Construction Drawings (PlansProfiles)_v1.pdf Markup Summary

8-29-2022

Cursory comments

LEMON GRASS ROAD (STREET L) - PUBLIC 50' R.O.W.
 25 MPH DESIGN SPEED (LOCAL)

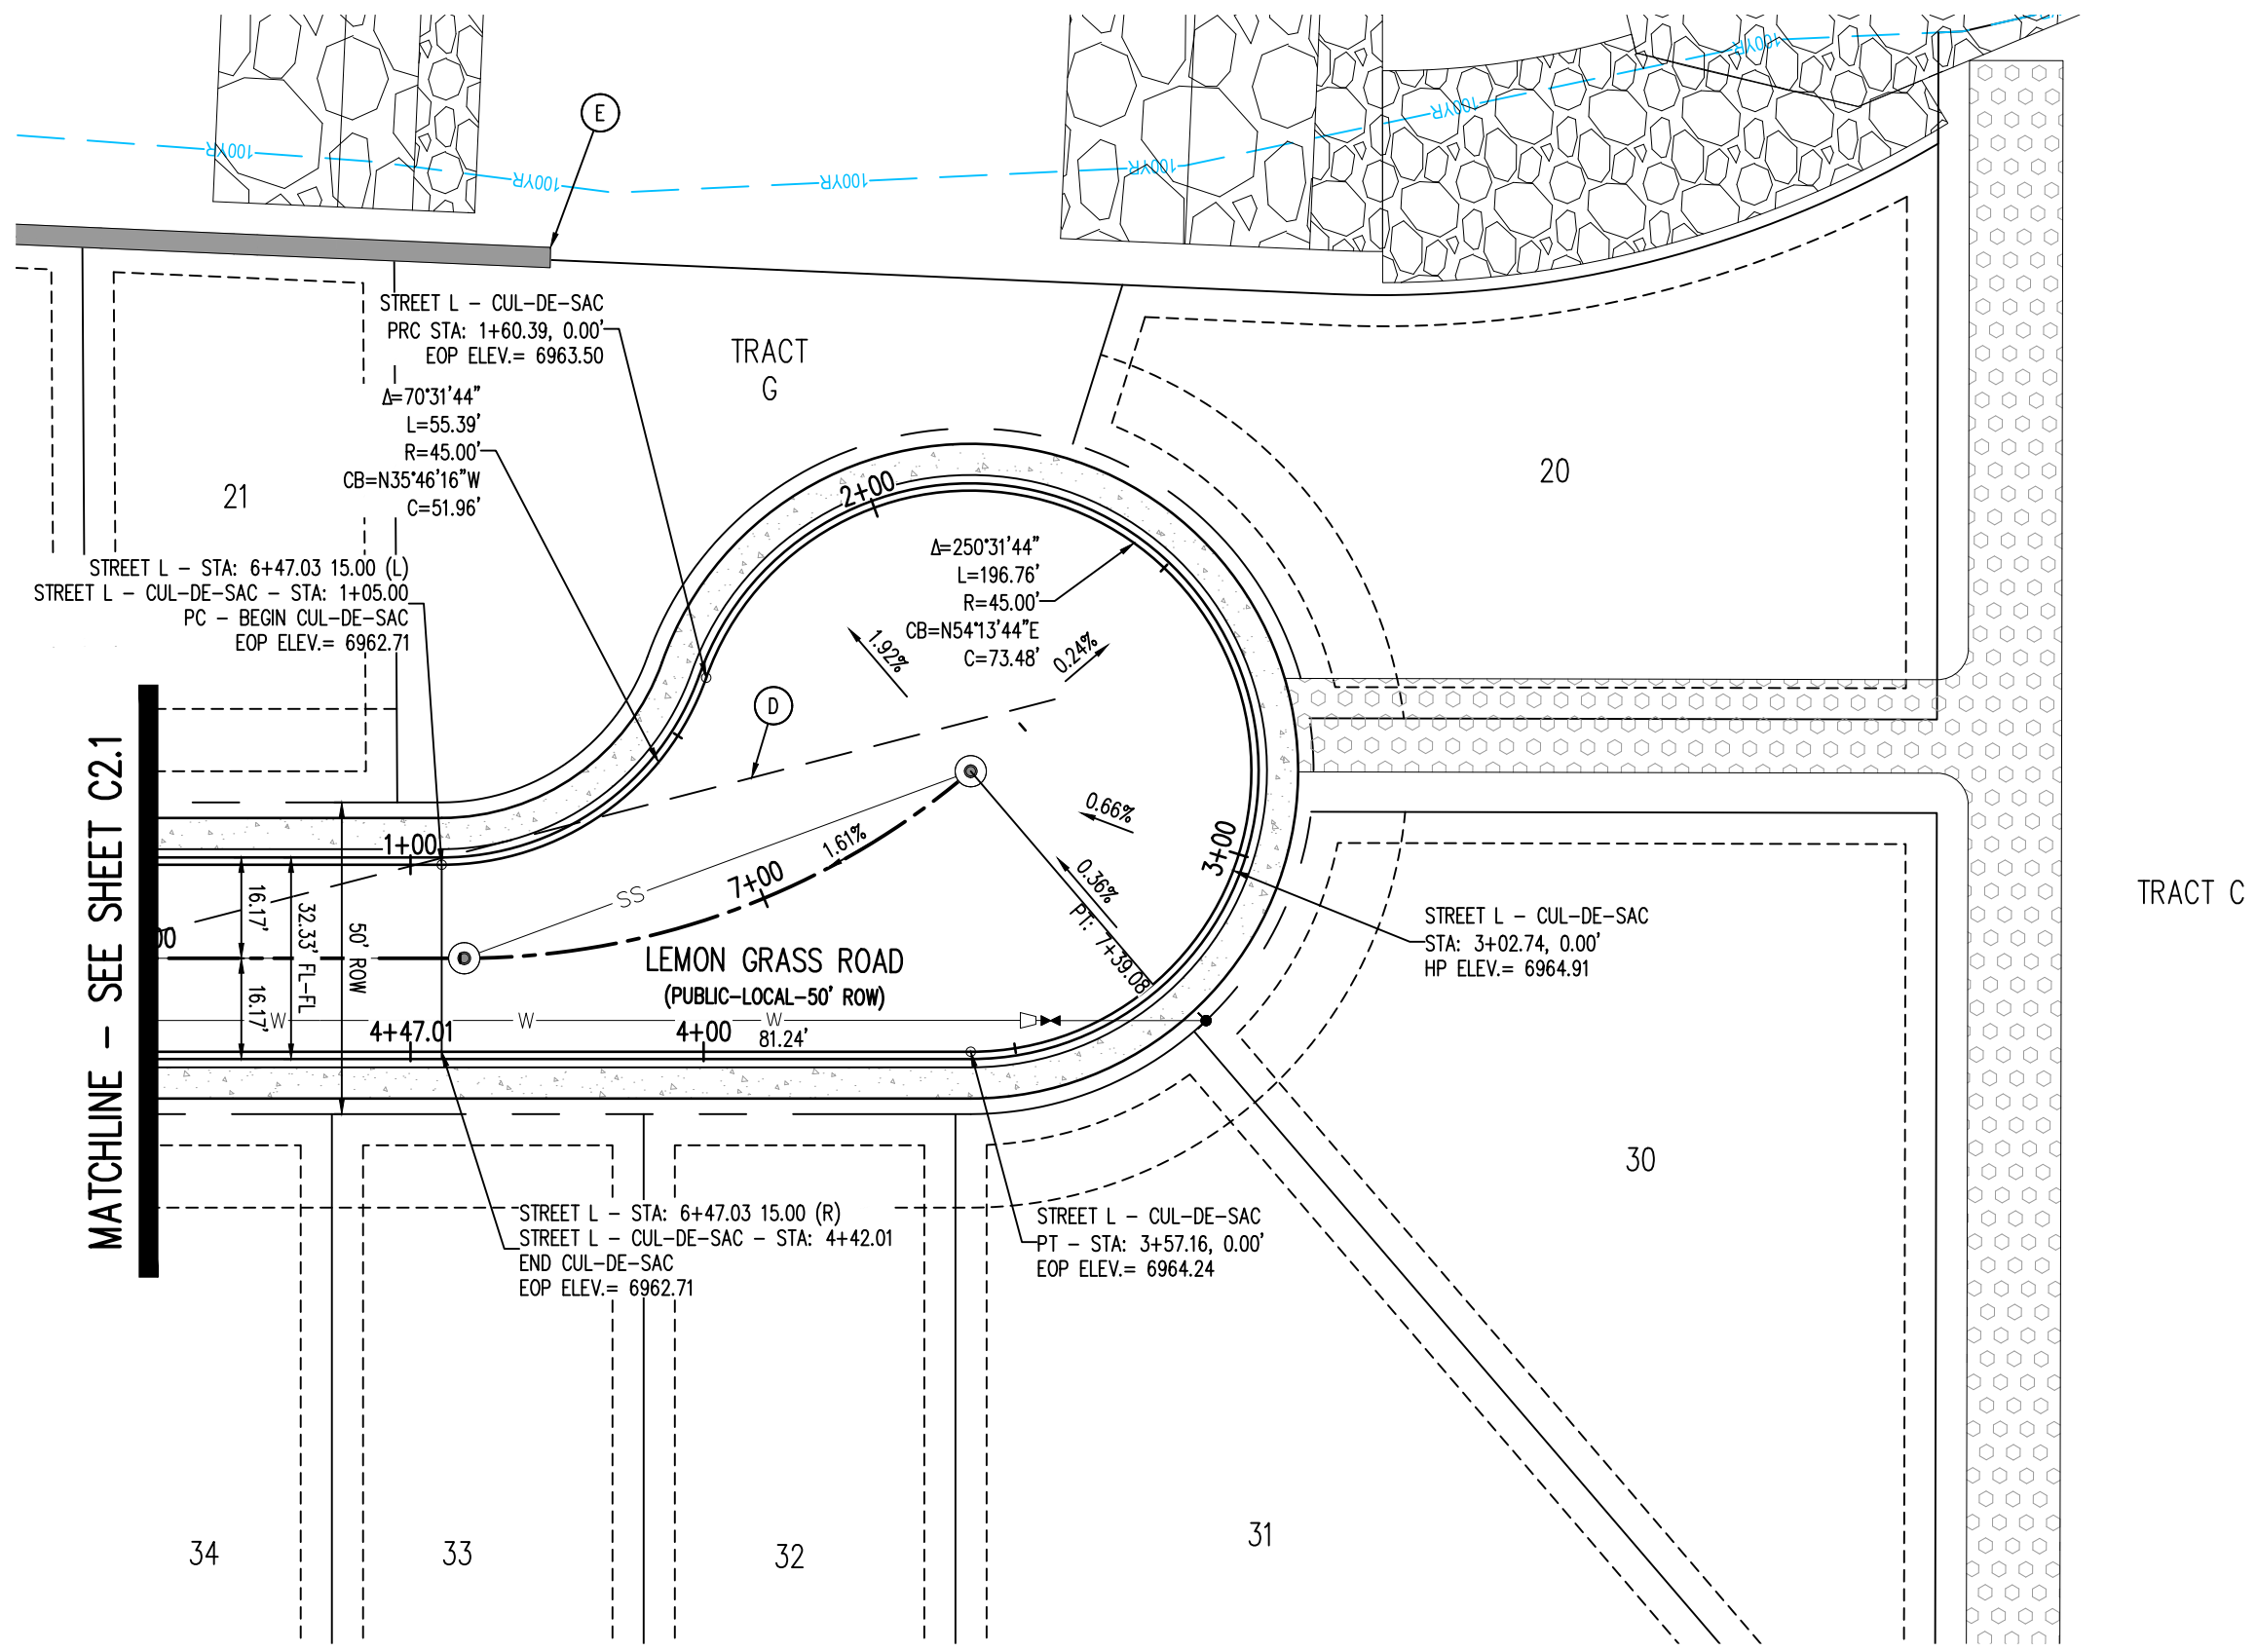
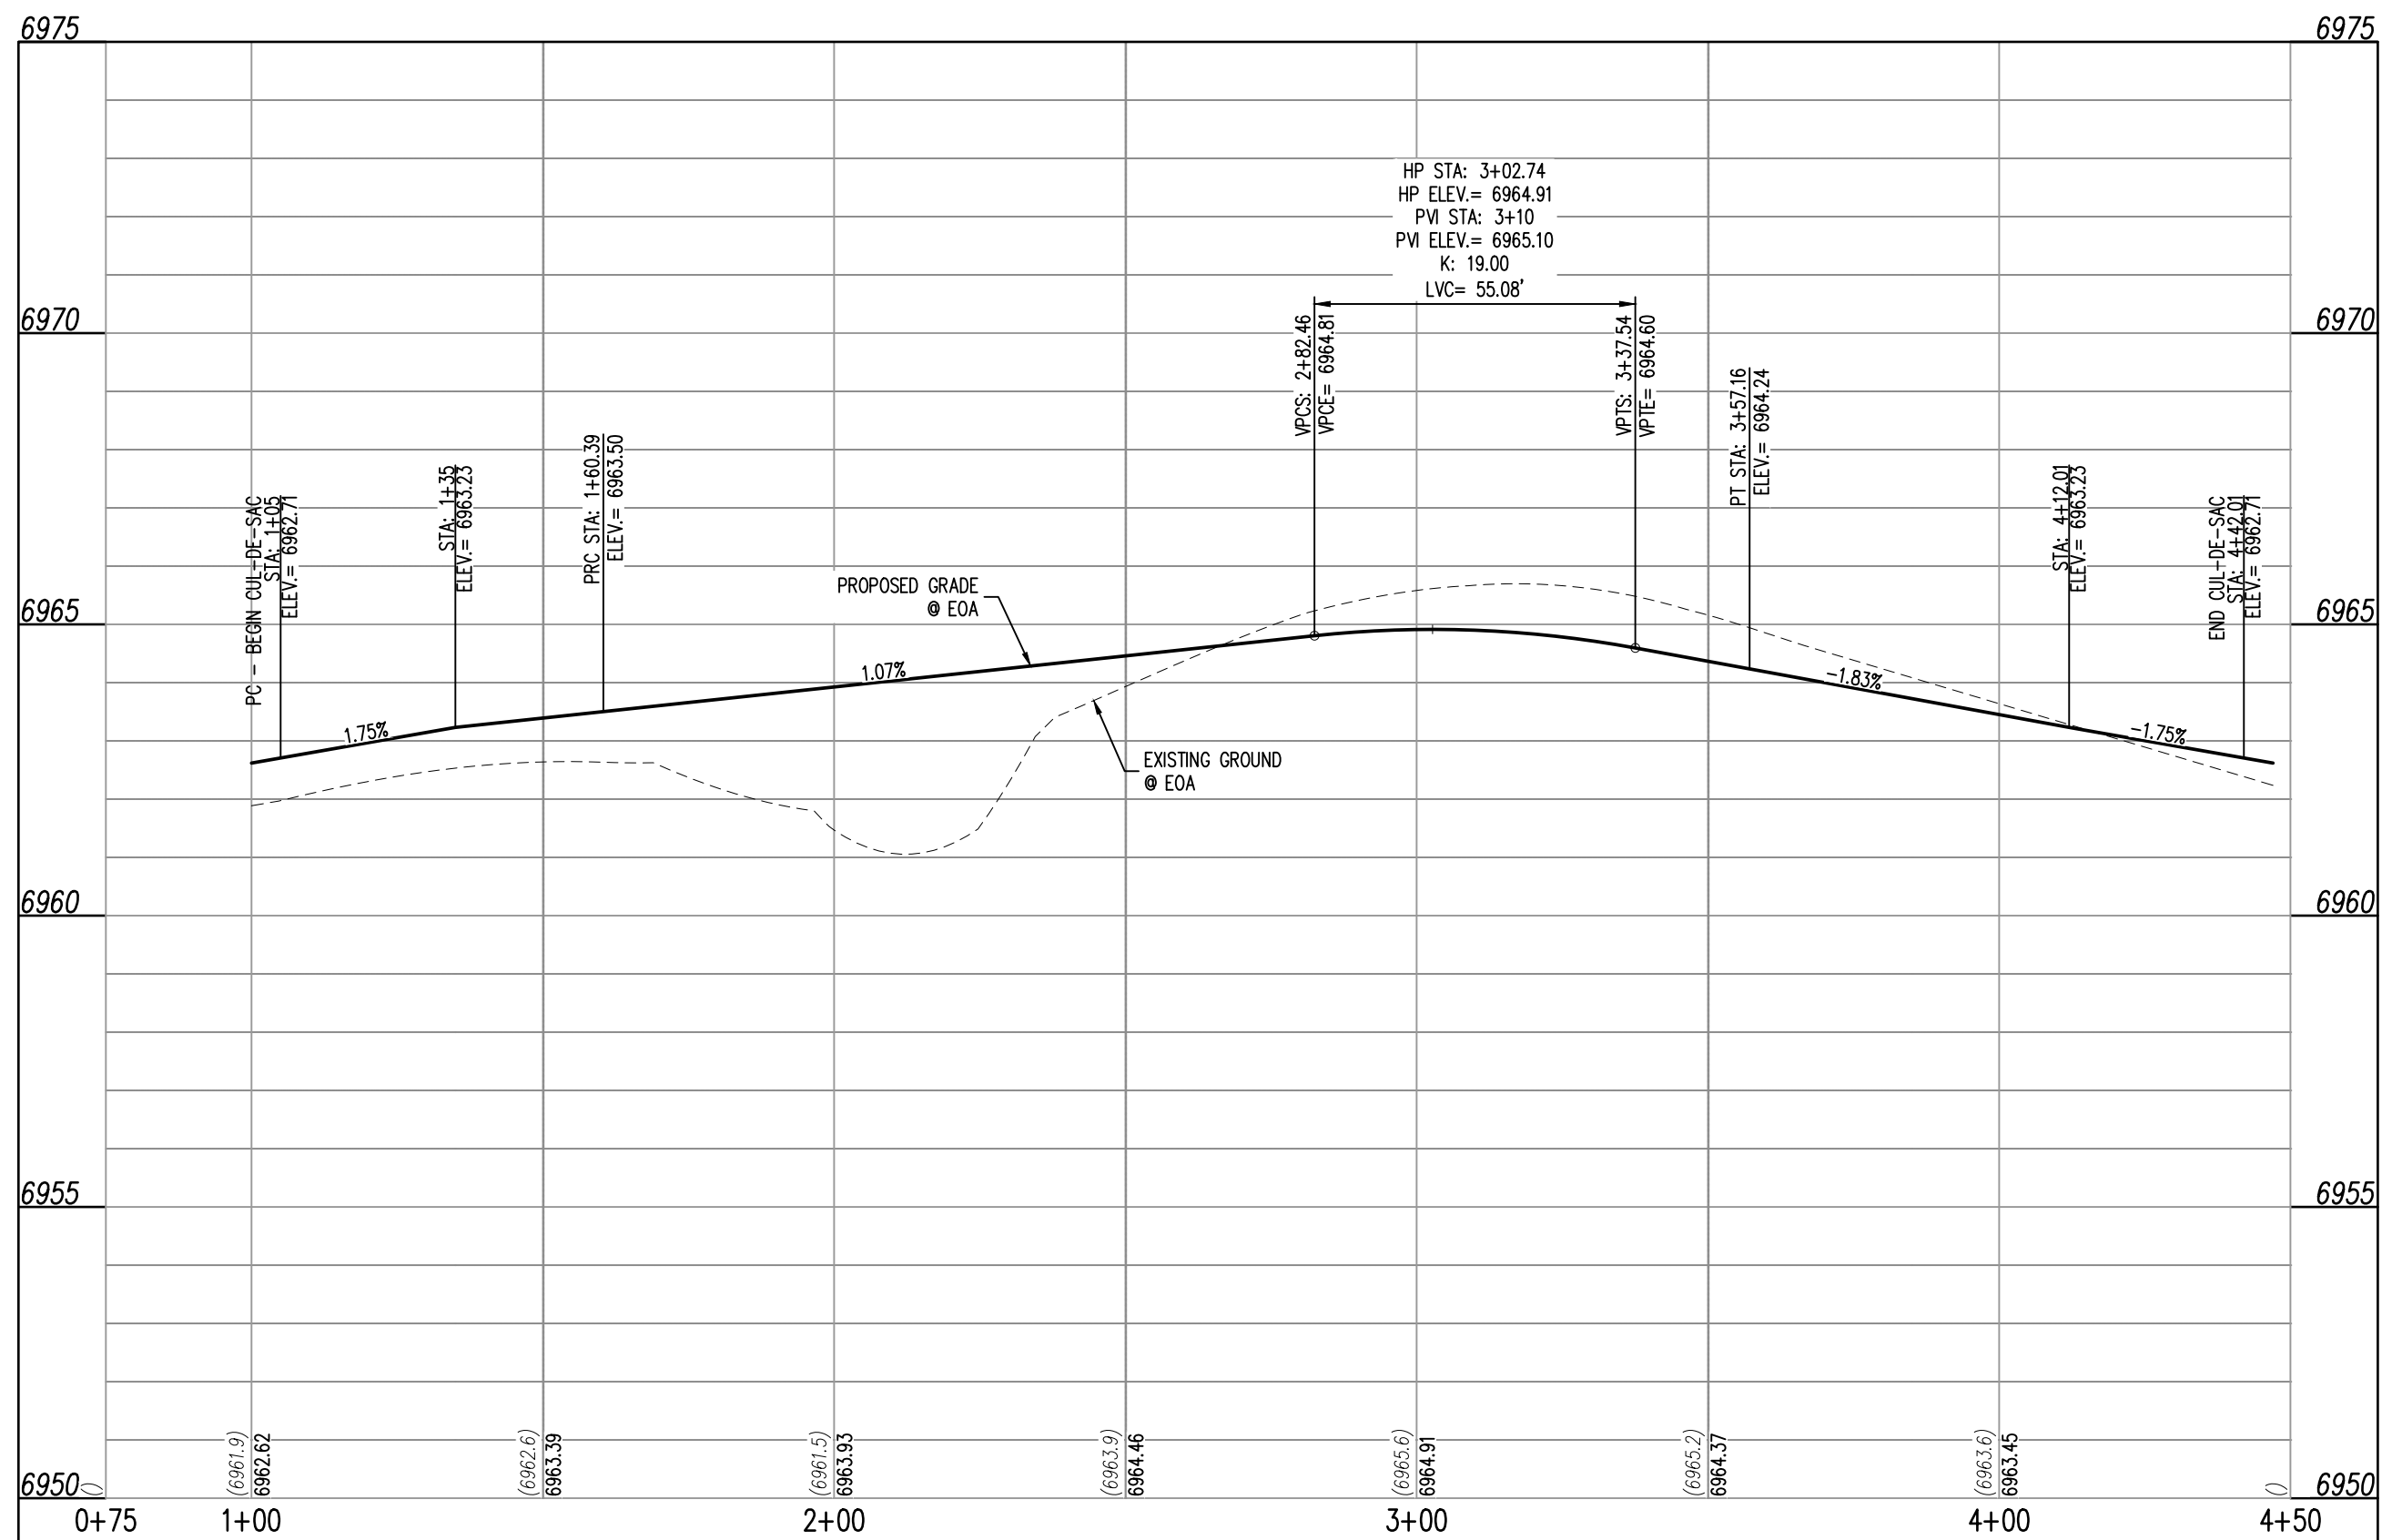
There appears to be a 3% grade break here - revise tangent to VC

Reduce grade break to <1% and space away from the vertical curve or remove and adjust the vertical curve

Subject: Callout
Page Label: [5] 5 LEMON GRASS RD IMPROVEMENT PLAN Provide vertical curves or reduce the grade break to $<1\%$
Author: dsdrice
Date: 8/19/2022 2:03:16 PM
Status:
Color: ■
Layer:
Space:

Subject: Callout
Page Label: [5] 5 LEMON GRASS RD IMPROVEMENT PLAN Does not meet minimum K values
Author: dsdrice
Date: 8/19/2022 2:05:14 PM
Status:
Color: ■
Layer:
Space:

Subject: Callout
Page Label: [5] 5 LEMON GRASS RD IMPROVEMENT PLAN Provide sight visibility triangles
Author: dsdrice
Date: 8/19/2022 2:46:29 PM
Status:
Color: ■
Layer:
Space:

Subject: Callout
Page Label: [5] 5 LEMON GRASS RD IMPROVEMENT PLAN Label as centerline-centerline intersections
Author: dsdrice
Date: 8/19/2022 2:48:41 PM
Status:
Color: ■
Layer:
Space:
